Dean Moor Solar Farm

Environmental Statement: Appendix 7.10 –Stakeholder Engagement on behalf of **FVS Dean Moor Limited**

March 2025
Prepared by: Stantec UK Ltd
PINS Ref: EN010155
Document Ref: 6.3
Revision: 1

Environmental Statement: Chapter 7 – Figure 7.5a ZTV of Work No.1 Solar PV Infrastructure with View Locations

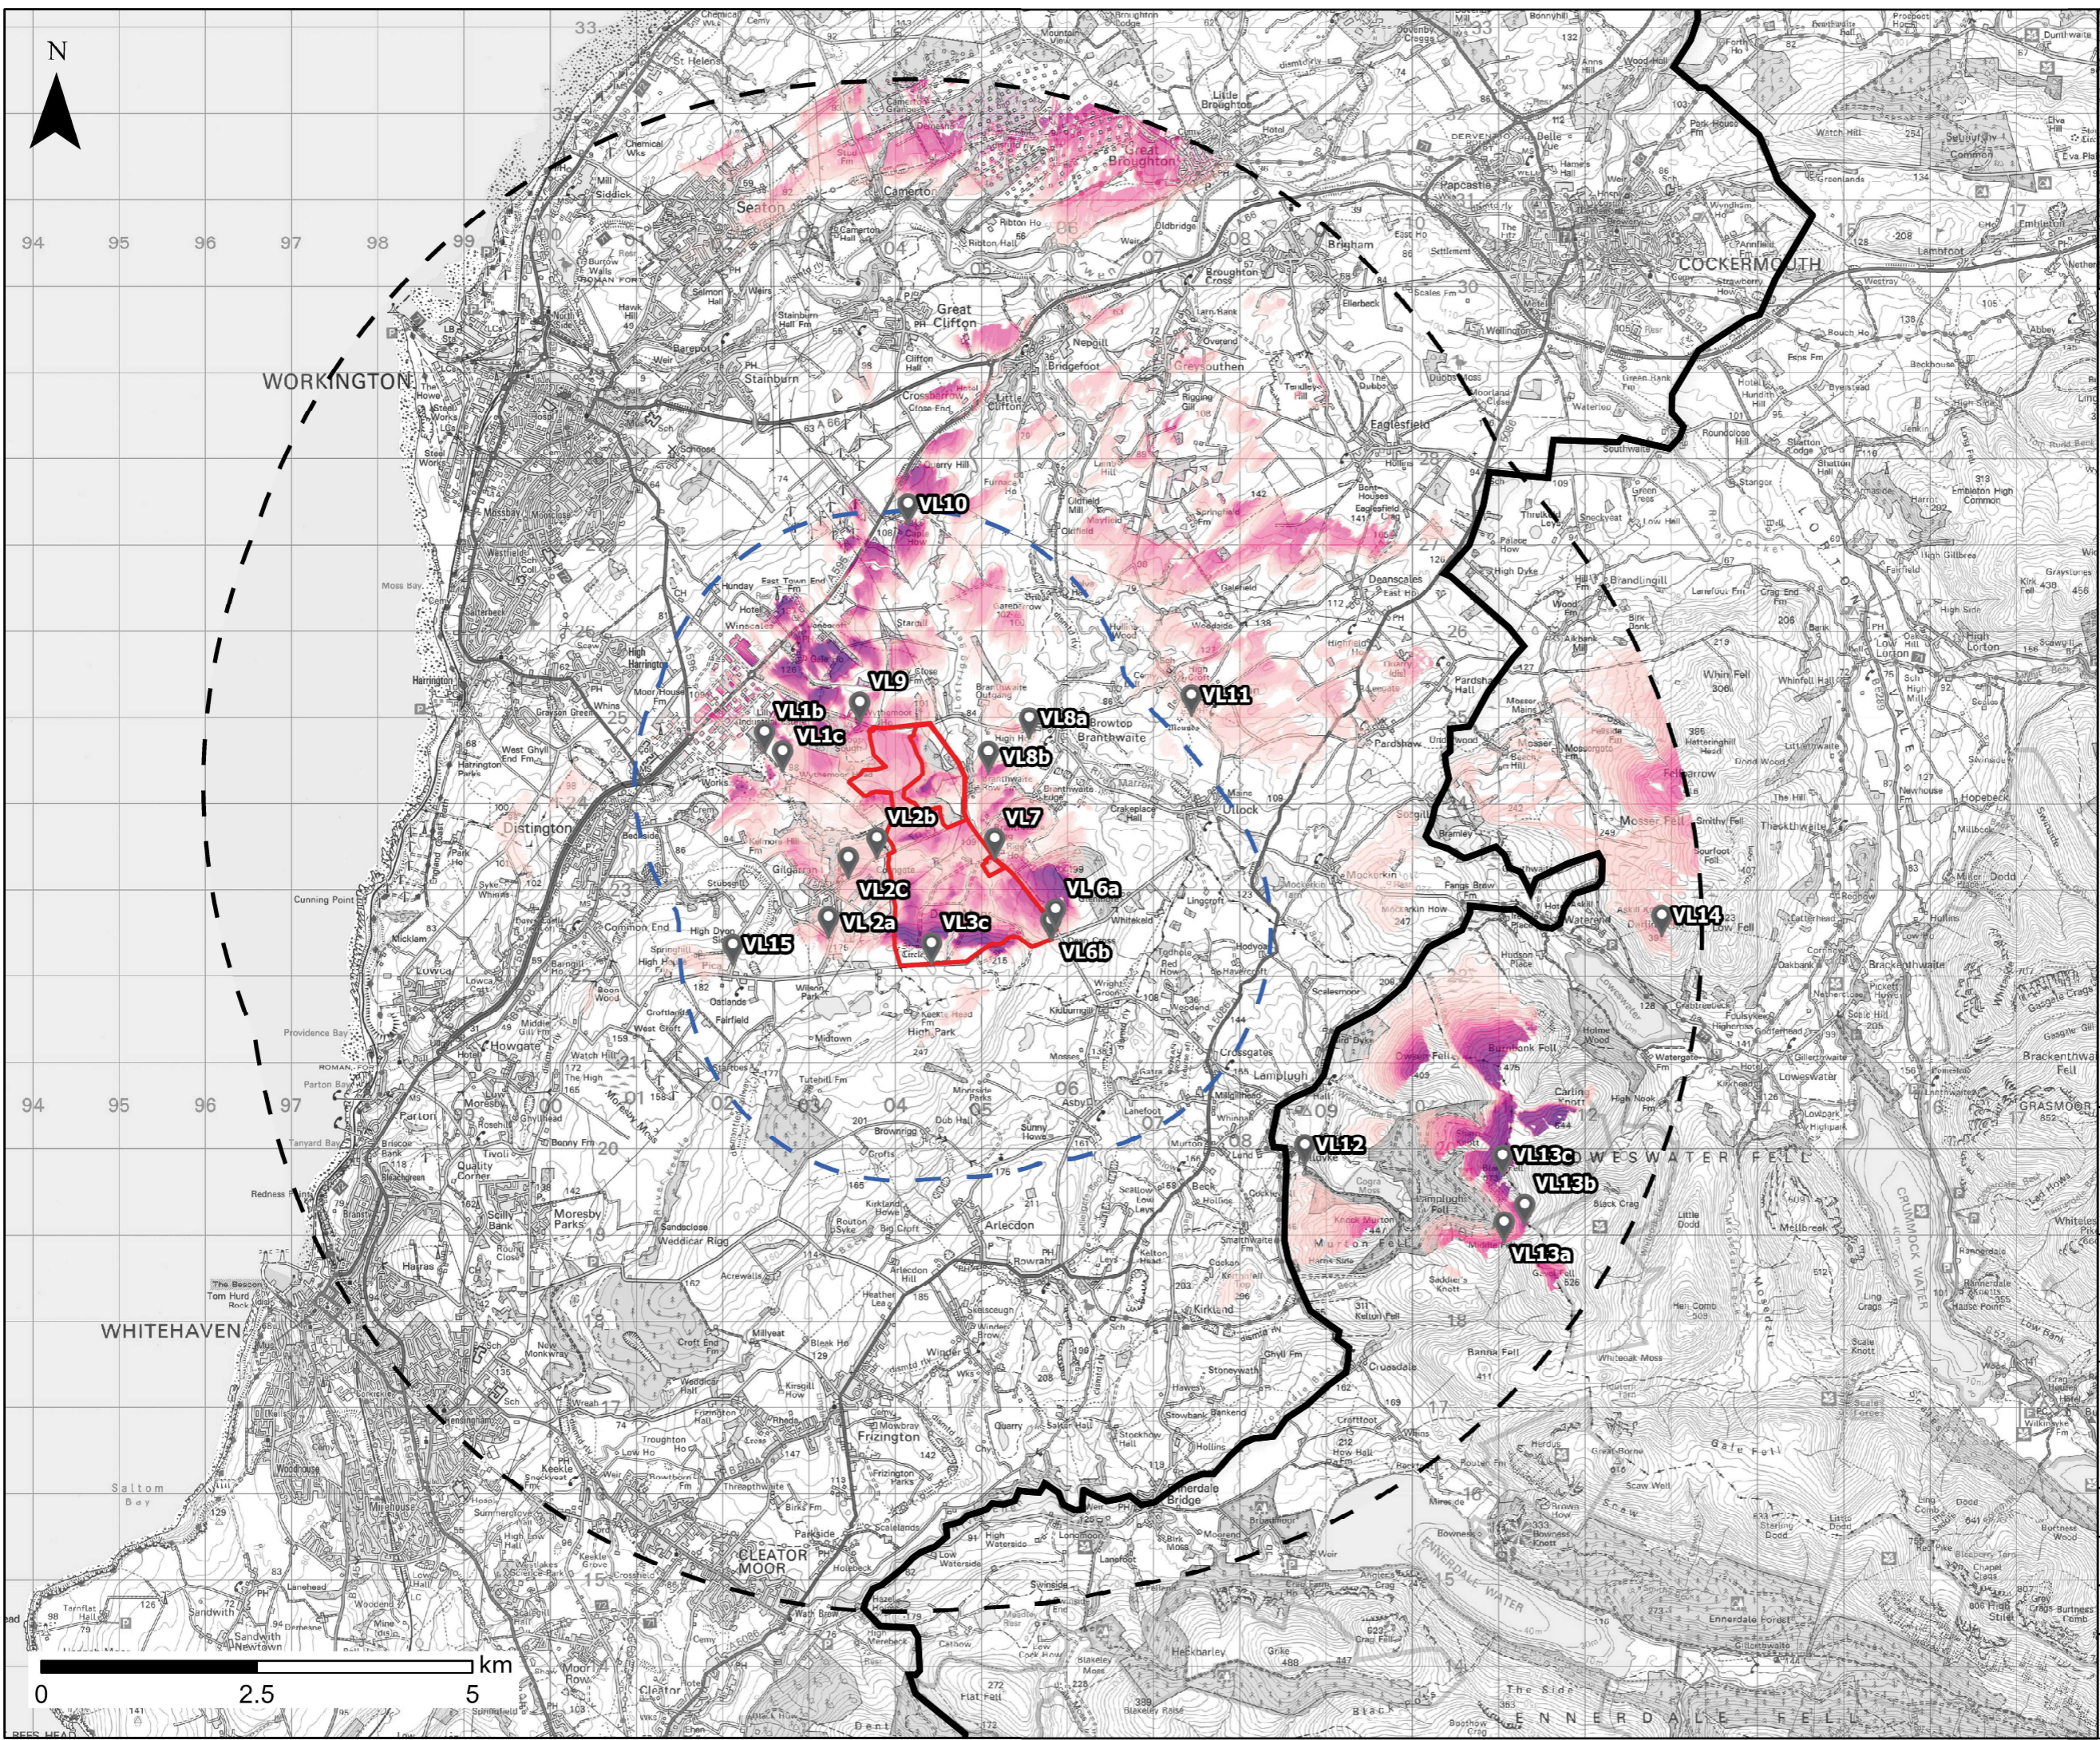
I agree that the view locations relating to the Lake District National Park (nos. 12, 13 and 14) are appropriate and representative.

12 will help to illustrate the effect from valley/settlement level. 13 and 14 will be important in illustrating the effect of downward and outward views from the fell tops which represent highly sensitive recreational users of the National Park.

From my fieldwork I am of the view that the chosen viewpoint location at Fell Dyke demonstrates a substantial absence of impact and that it is not necessary to pursue this location as a point for the 1 and 15 year scenarios:

- VL12 Local PRoW (412025) near Cogra Moss / Felldyke within the Lake District National Park / WHS (a 90degree view centred to the north-west)

To assess the impact on the National Park I would recommend that the viewpoint of Blake Fell be selected for this purpose:

- VLC 5: Dean Moor VL13 View from Blake Fell within the Lake District National Park / WHS

I still maintain that a representative view from the Fellbarrow range would be appropriate to include and perhaps this could be included in the section of the report dealing with the cumulative effect with Lost Rigg.

As an update [REDACTED] and [REDACTED] from the LDNPA have responded and asked that we replace VL12 with VL13 for a visualisation, which we have confirmed will be done. Our proposed approach as set out below for the remainder remains valid.
